Ribble Valley Borough Council
Housing & Development Control

Application no: **3/2023/0410**

Address: **Cunliffe House Farm Longsight Road Langho BB6 8AD**

Proposal: **New single storey detached building to be used as a fire/stove showroom along with parking spaces.**

Proposed Site Plan 1:200

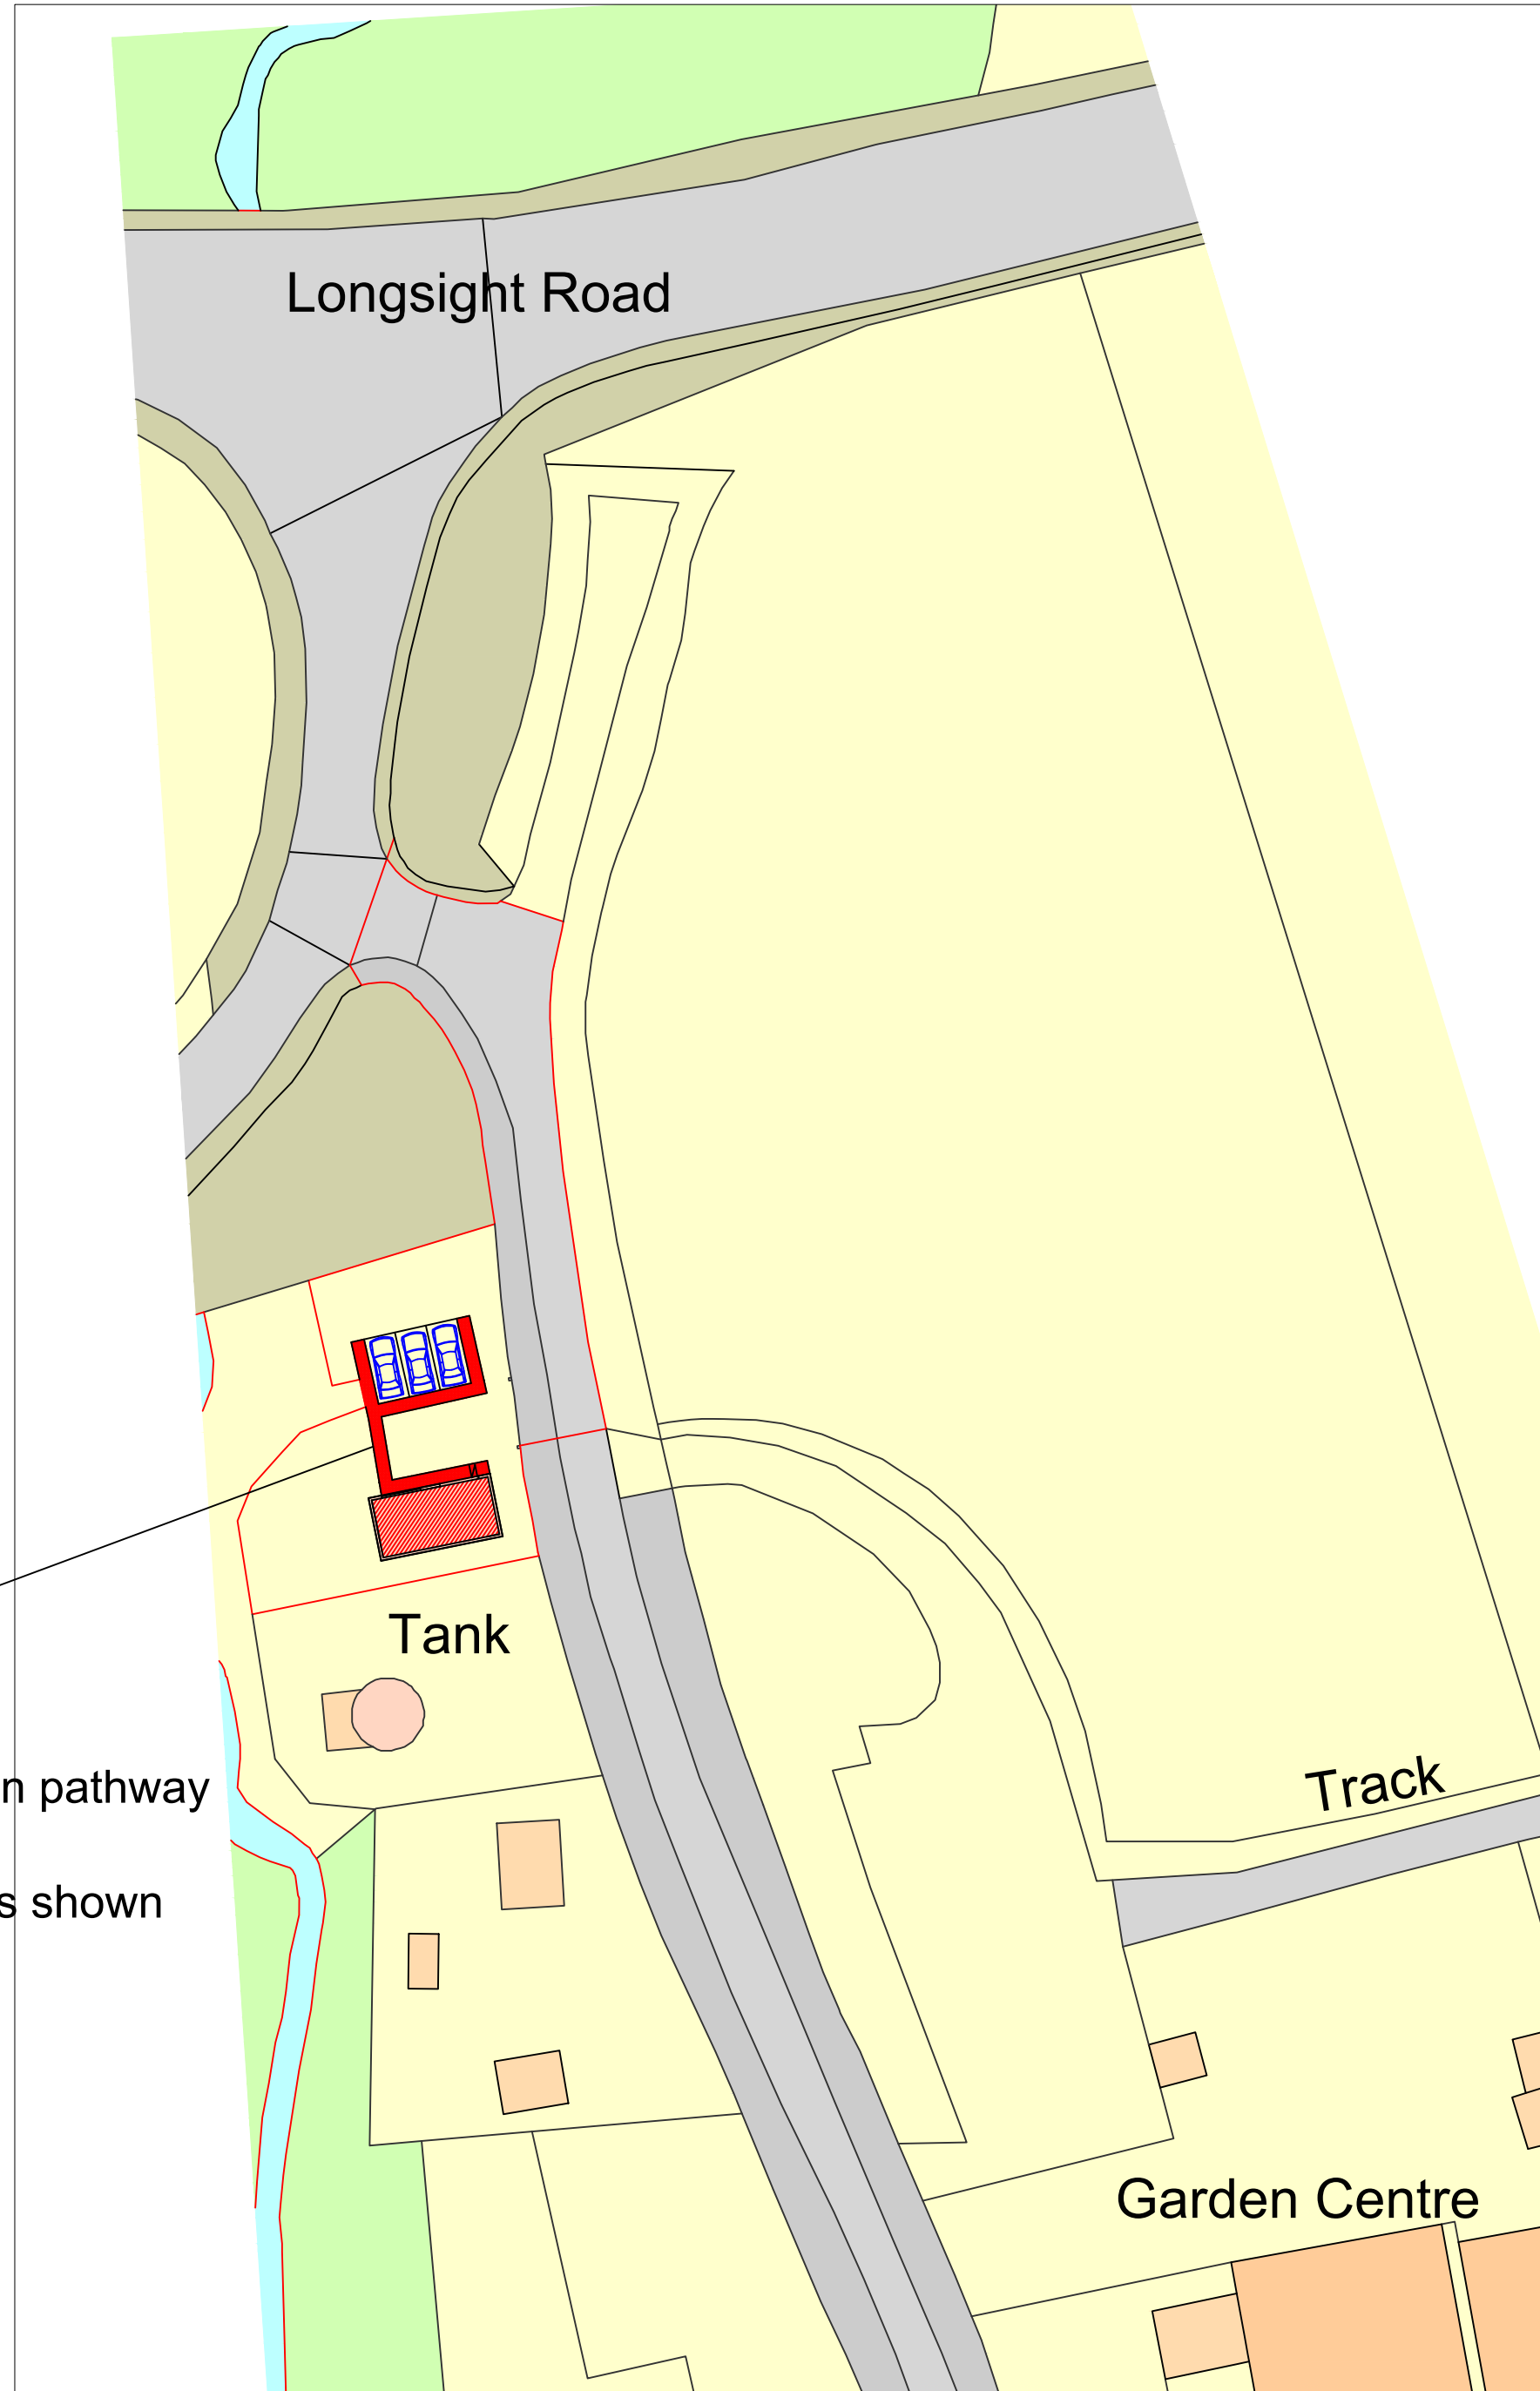
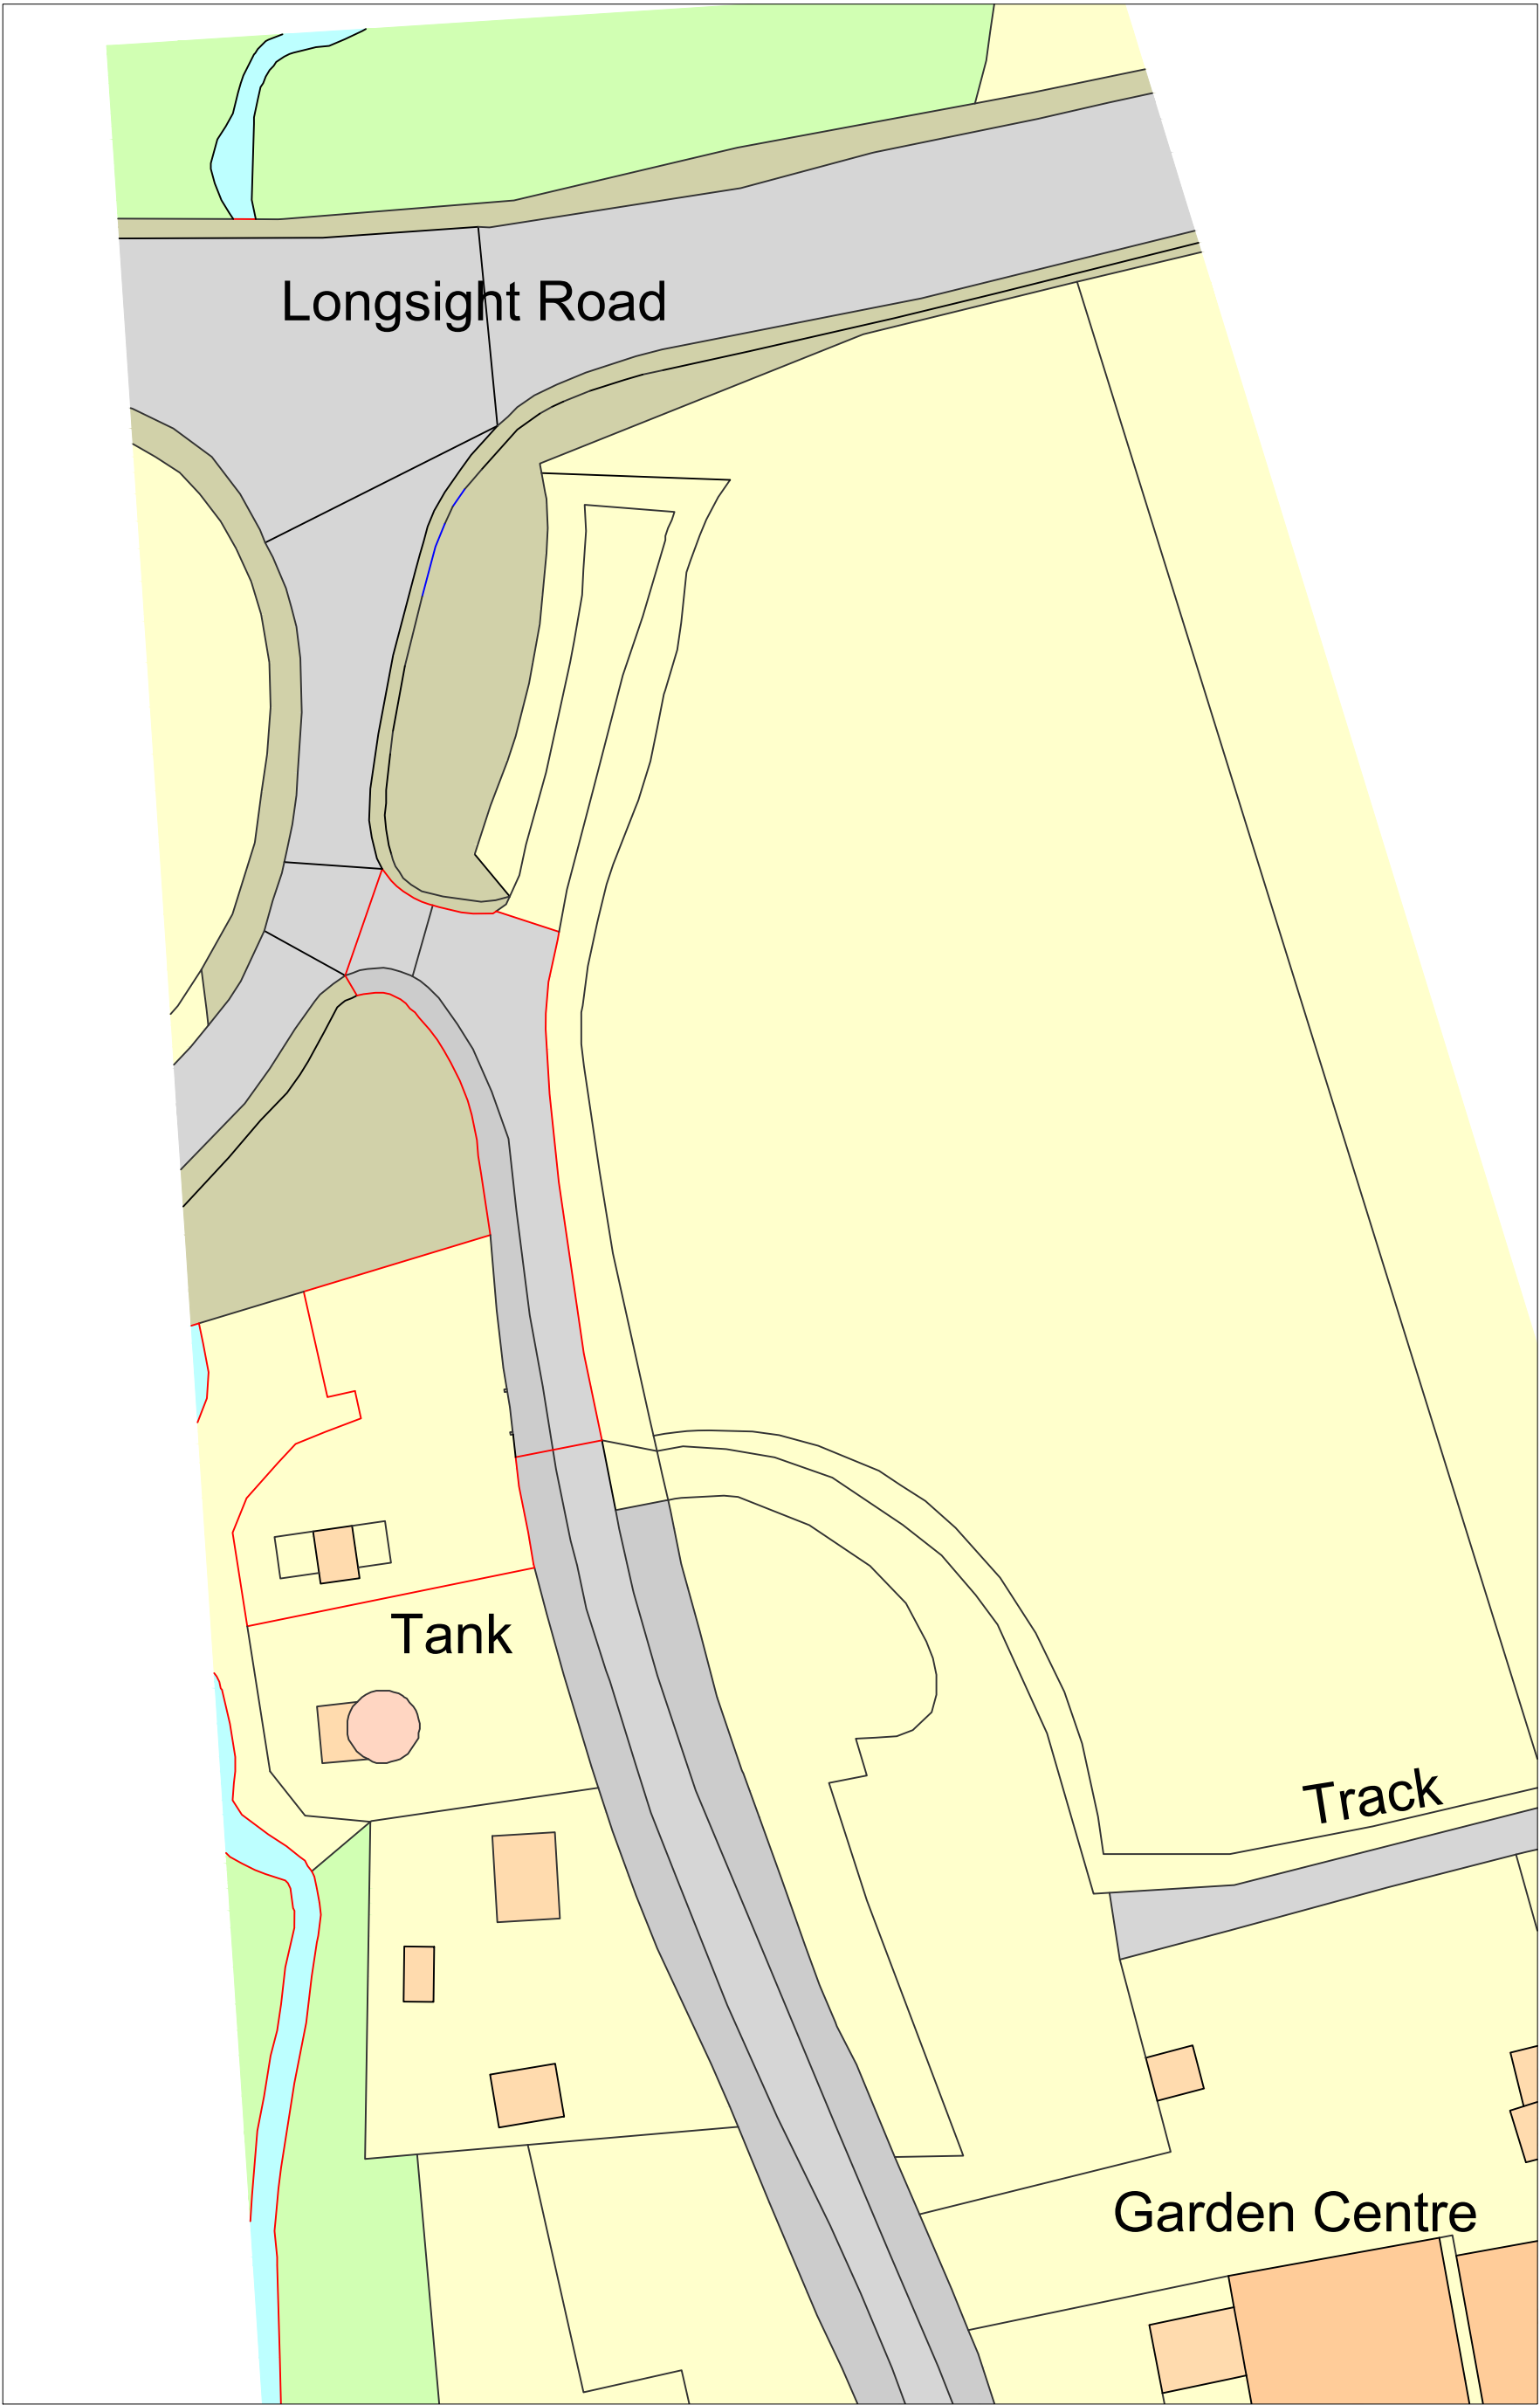
The LHA previously responded to the application on 9th August 2023, requesting that the access is widened to 6m. Since then, a revised plan has been submitted hence Entwistle Design drawing number 2 of 2 Site Plan Amended 18/08/23. This information will be reviewed below.

The LHA have reviewed Entwistle Design drawing number 2 of 2 Site Plan Amended 18/08/23 and are aware that the proposal will utilise an existing access to serve the site. The access will be approximately 6m wide which complies with the LHAs guidance.

The LHA have reviewed Entwistle Design drawing number 2 of 2 Site Plan Amended 03/08/23 and the Operation Statement and are aware that the parking arrangements comply with the LHAs guidance as defined in the Joint Lancashire Structure Plan.

However, the LHA are aware that the plan has not shown where the site will be serviced from internally but has stated in the Operation Statement that deliveries will be made by transit type vehicles once a week. Due to the infrequency of deliveries, transit type vehicles servicing the site and the LHA conditioning that customers visit the site on an appointment only basis, the LHA are satisfied that deliveries can be managed internally without the need for a formalised area.

1. No part of the development hereby permitted shall be occupied until such time as the access arrangements shown on Entwistle Design drawing number 2 of 2 Site Plan Amended 18/08/23 have been implemented in full.

4. The development hereby permitted shall not be occupied until such time as the parking and turning facilities have been implemented in accordance with Entwistle Design drawing number 2 of 2 Site Plan Amended 18/08/23. Thereafter the onsite parking provision shall be so maintained in perpetuity.
